**Tarrawonga Coal Mine MOD 7 (MP11_0047 Mod 7)
Request for Additional Information**

I refer to the meeting held on 2 December 2020 between the Department, the Department's groundwater expert and Whitehaven representatives to discuss the assessment for the Tarrawonga Coal Mine Modification 7 (MP11_0047 Mod 7). After careful consideration, the Department requests that you provide the following additional information.

Figure 1. Location of flood bund relative to pit extent and alluvial boundary

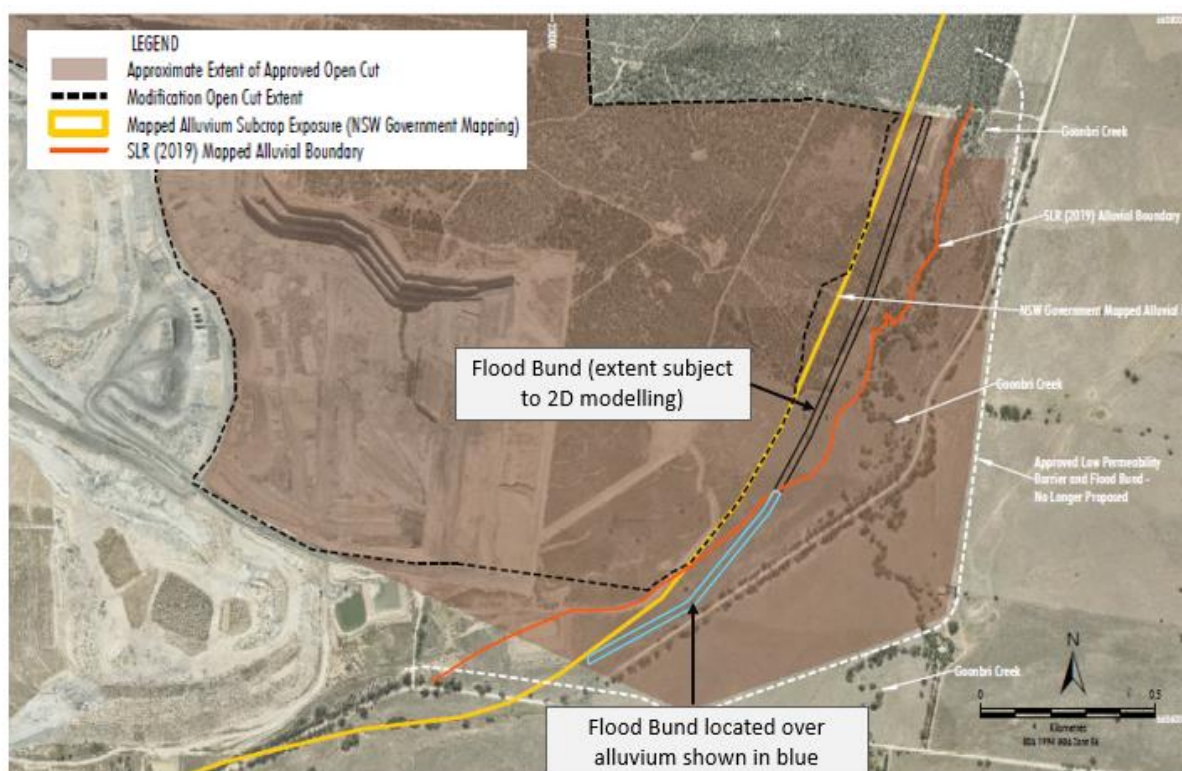
- clarification of the alignments/setbacks of the pit crest from the mapped alluvium and flood bund;
- consideration of the potential for leakage towards the pit and/or post mining void via the alluvium due to floodwater ponding against the flood bund and/or mapped alluvium;
- consideration of potential pathways via fractured rock from blasting; and
- consideration of any additional reasonable and feasible mitigation measures (such as keying the flood bund into the bedrock where it is located on the alluvium).
